Subject: Shoreline Exemption Permit, Flushing Station 12 – 4000 E. Mercer Way.

This is a written response to the review comments provided by the Community Planning and Development Department regarding the application for the Shoreline Exemption Permit, SHL23-001, for Flushing Station 12 located at 4000 E. Mercer Way.

FLUSH STATION 12
- PLAN

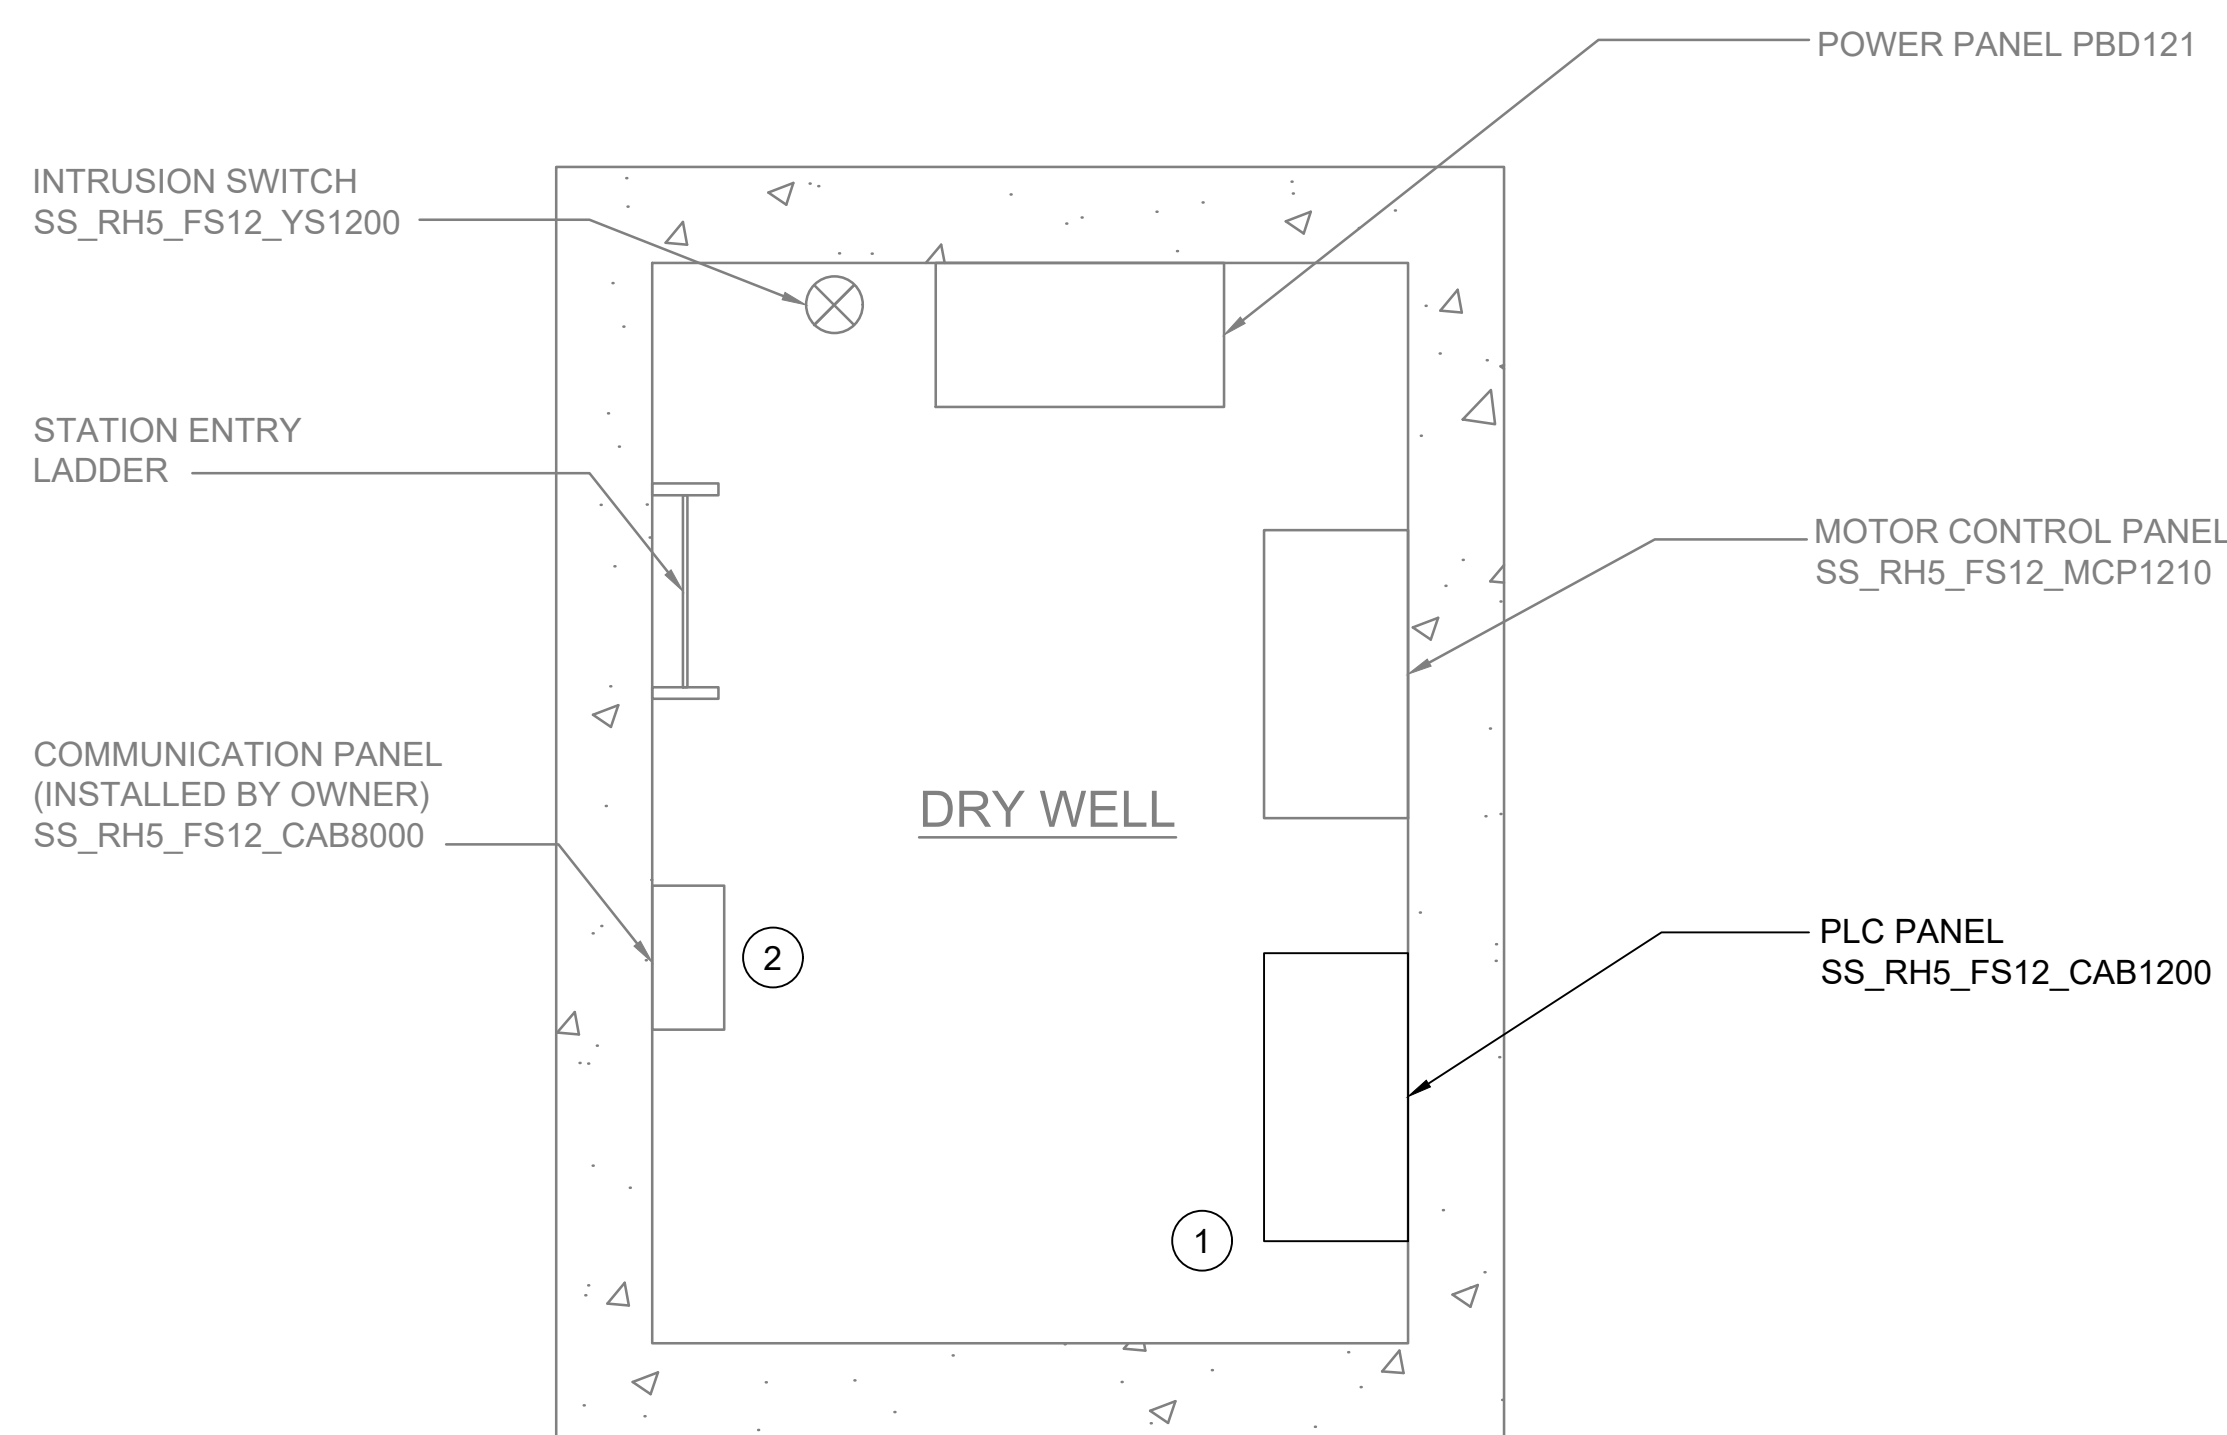
- a. Provide address of all pump stations on plans

**Response:** *The address for the pump station has been added to Development Plan, Instrumentation Drawing page 1. The address was also included in the aerial photo of the pump station.*
